Our Ref: R/273/19/NMA

**Section 96A of the Town & Country Planning Act 1990 (as amended)
Town and Country Planning (Development Management Procedure) (England) Order 2015 (as amended) - Article 10**

Non-material amendment following the grant of reference R/117/19/PL to remove door on east elevation, remove window on north elevation and new door on north elevation to provide fire escape
Rustington Hall Nursing Home Station Road Rustington BN16 3AY

PROPOSED ELEVATIONS 1:100

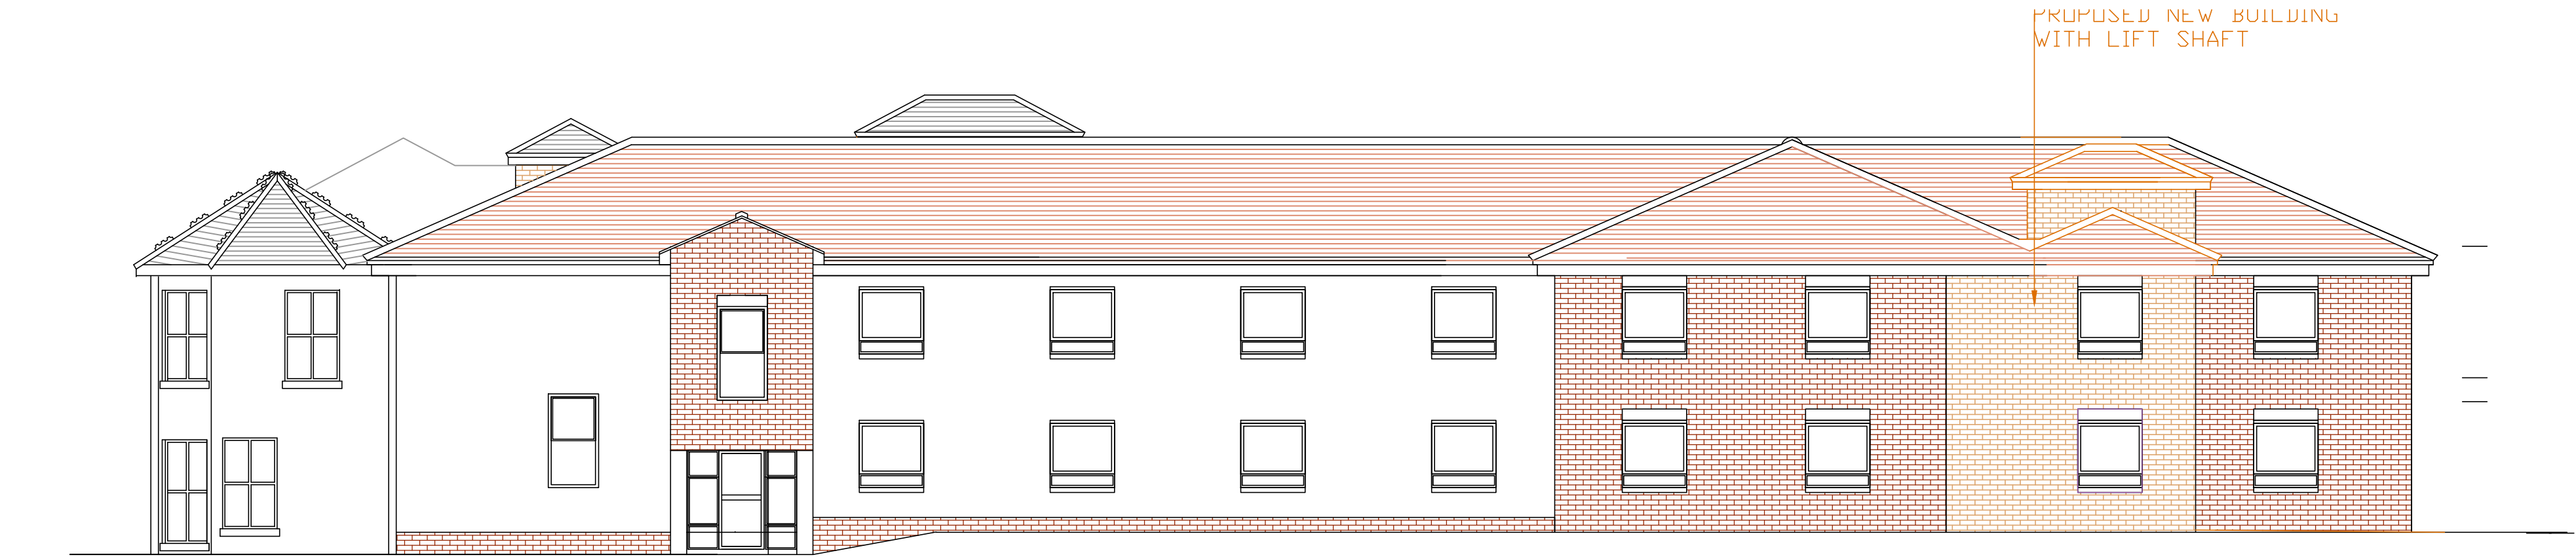
I refer to your recent application for a Non Material Minor Amendment. I note that you seek to remove a door on East elevation, remove a window on the North elevation, and add a new door on the Northern elevation.

Please note that plans 'Proposed Ground Floor Plan - (infill courtyard, lift and store) - 181/103PROP - GFR1 - 14/06/19' and '- Proposed Elevations - 18131/01ELEVS - r1' are replaced by 'Proposed Ground Floor Plan - (infill courtyard, lift and store) - 181/103PROP - GFr3 - 08/11/19' and 'Proposed Elevations - 18131/01ELEVS - r1 - 14-06-2019'.
